Consultation Response from: KC Environmental Health (Pollution & Noise Control)
2024/91853 - Birkenshaw Liberal Club, 10, Croft Street, Birkenshaw, BD11 2HT
Erection of 18 dwellings with garages, formation of adoptable road, private road and parking spaces and new car park and beer garden for the Liberal Club
Date Responded:
19 August 2023
Responding Officer:
NH and MN
Responding Ref:
WK/202423717
Noise

Appendix 2 – Noise Measurement Positions

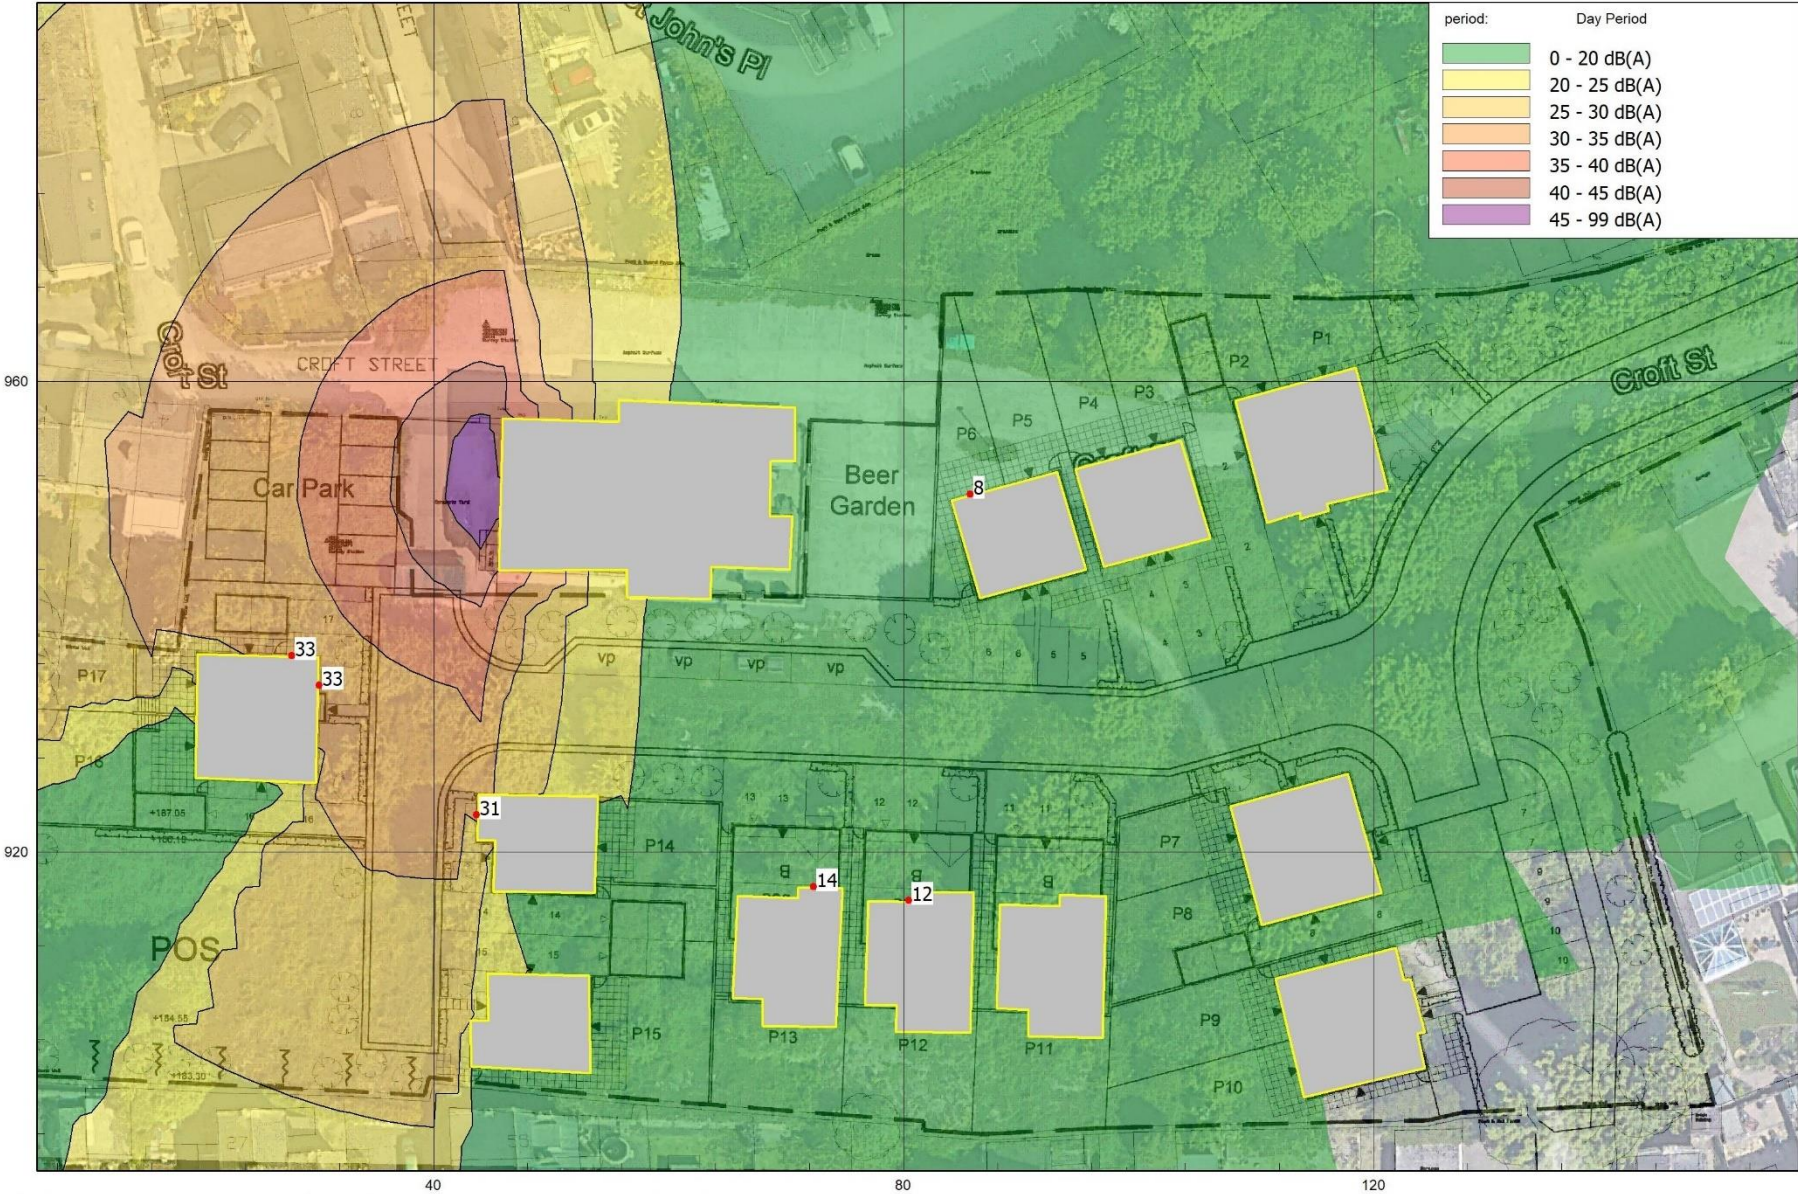
Noise monitoring was carried out on Tuesday the 26th of March 2024, and on Wednesday the 24th of April through to Thursday the 25th of April 2024 from four monitoring positions (MPs) as shown in Appendix 2. A summary of the findings is given in table 3.1 with the report stating the noise environment at the site was dominated by distant traffic on the surrounding road network, with some birdsong. No noise was noted from the Birkenshaw Liberal Club.

Exploratory Hole Location Plan, 48785-ECE-XX-XX-DR-C-0001 [P04](#)

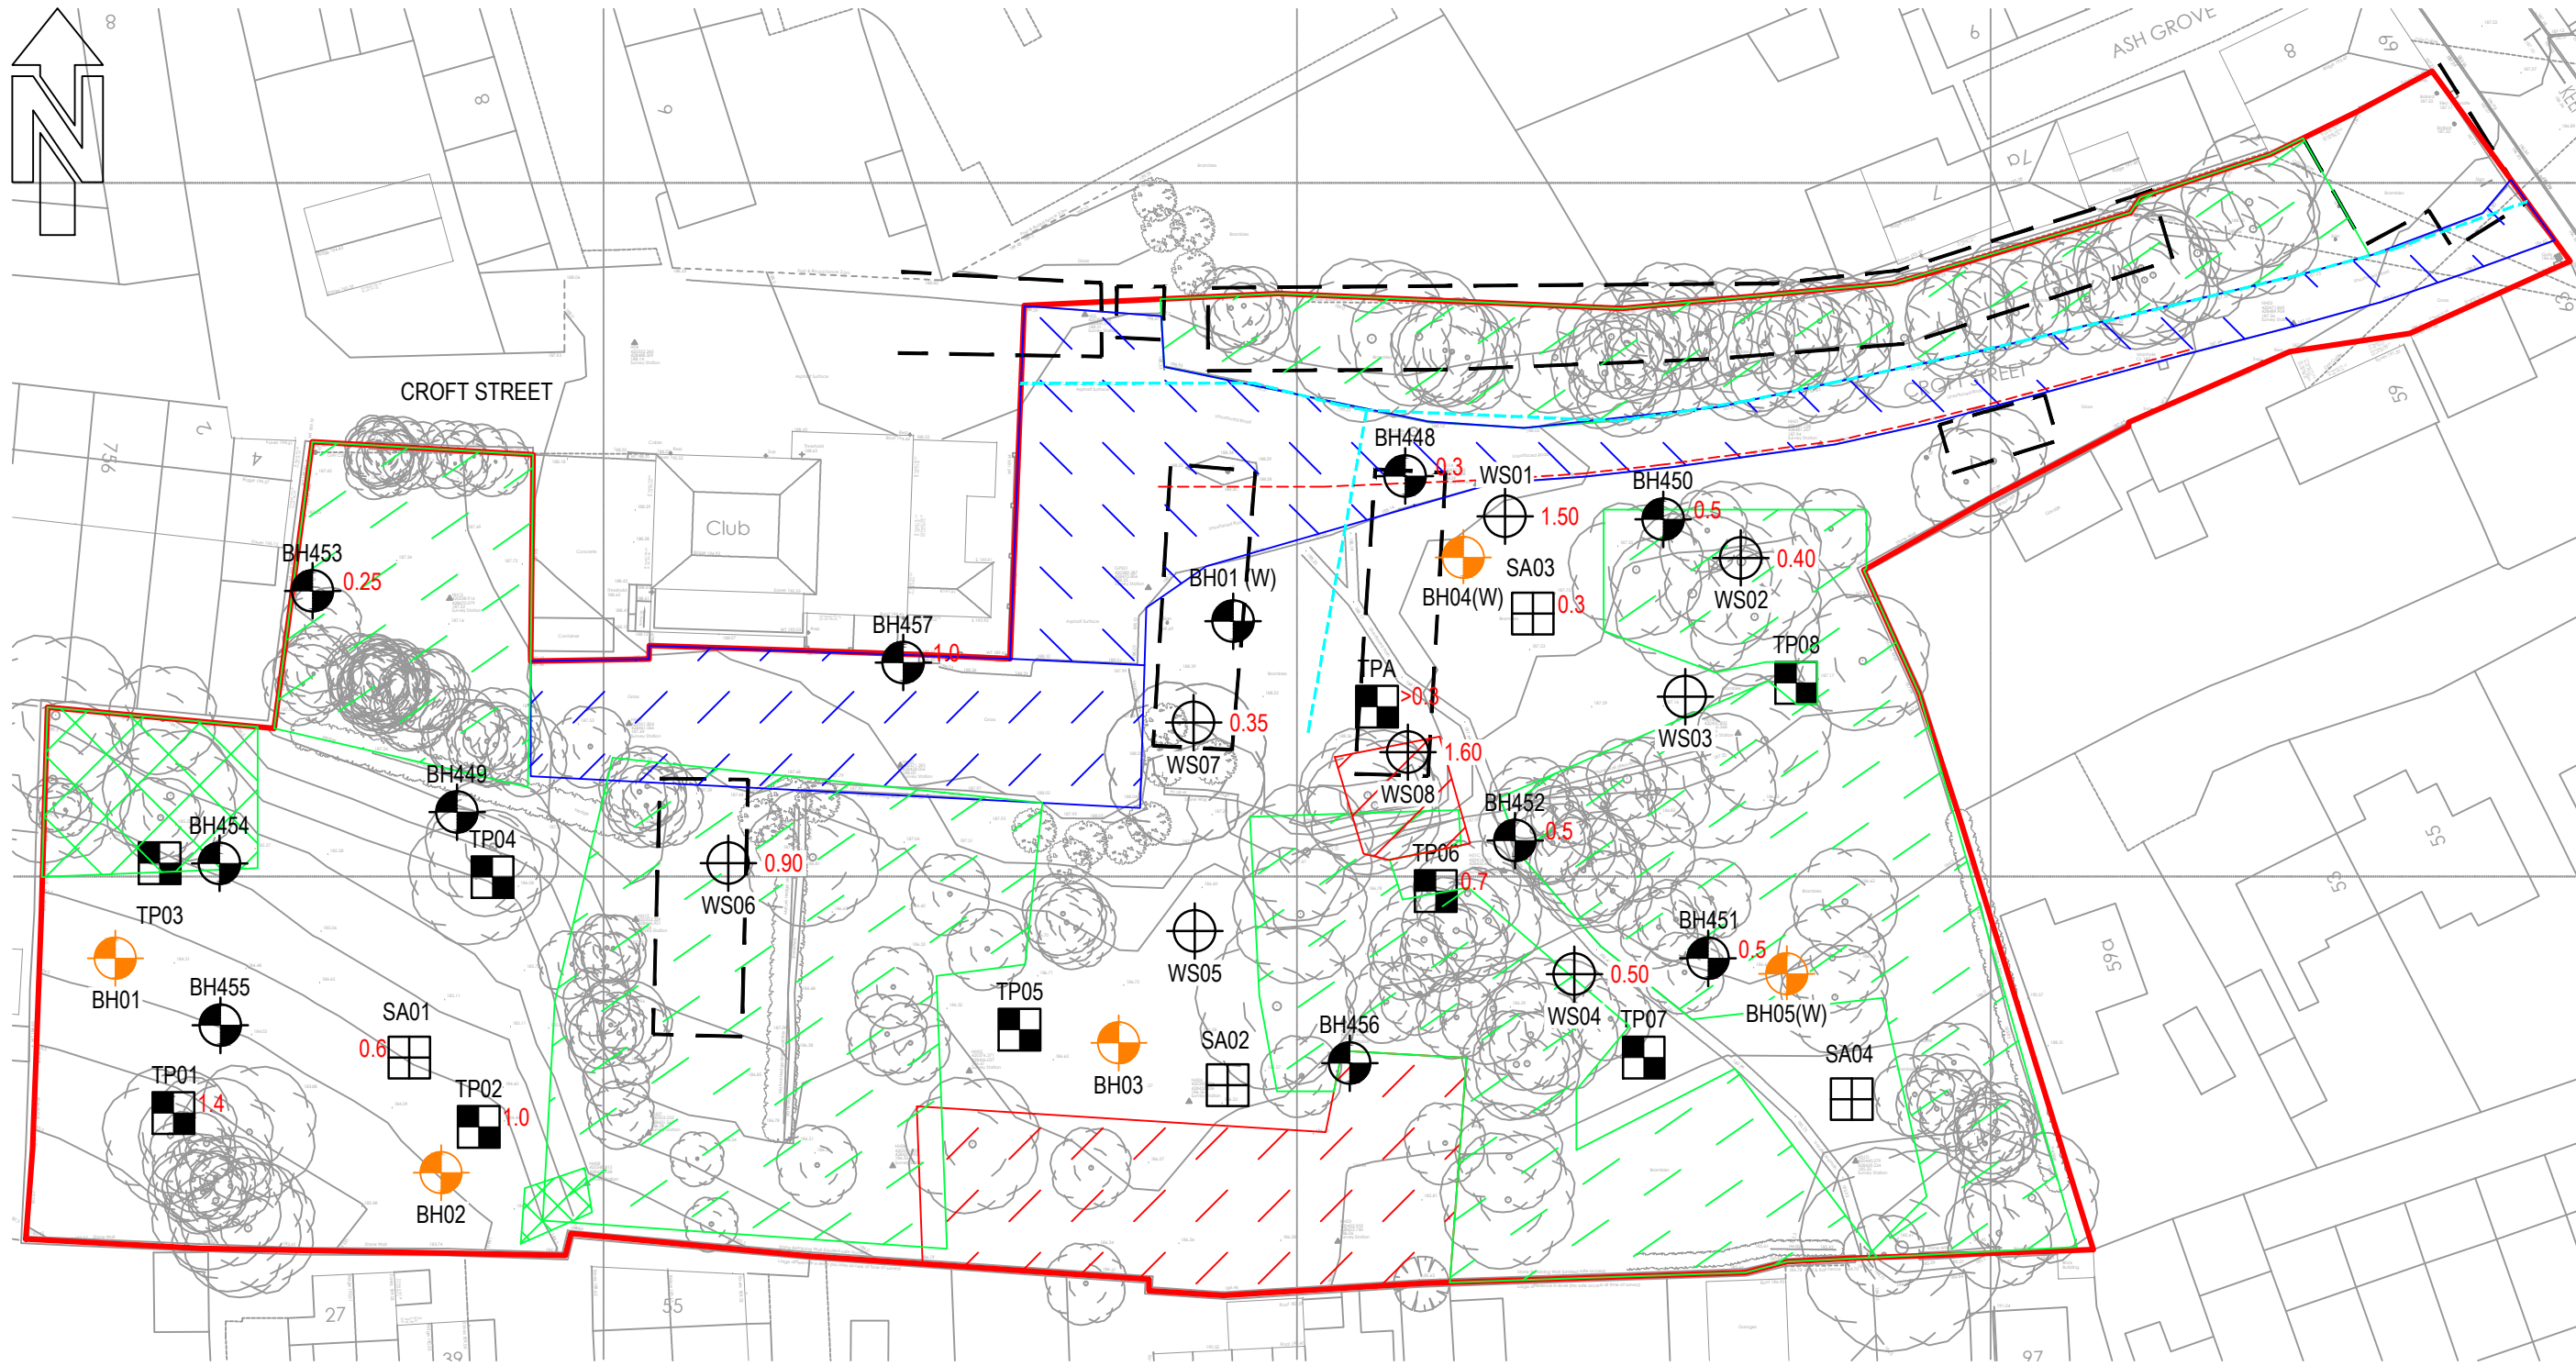
- Broken ground was found at shallow depths, possibly associated with shallow coal workings. In addition, access limitations due to dense vegetation prohibited the investigation of areas of former housing. These areas were noted as possibly having deep made ground due to former cellars. These are potential ground gas risks. However, ground gases have not been monitored for. We expect a revised report that provides robust justification for the lack of ground gas monitoring. Alternatively, ground gas monitoring should be undertaken in accordance with good practice guidance.
- We request clarification of the areas requiring additional testing following demolition and proposals for the testing of these areas. This should include an update plan.

Groundworks (other than those required for a site investigation report) shall not commence until a Phase II Intrusive Site Investigation Report by a suitably competent person has been submitted to and approved in writing by the Local Planning Authority.
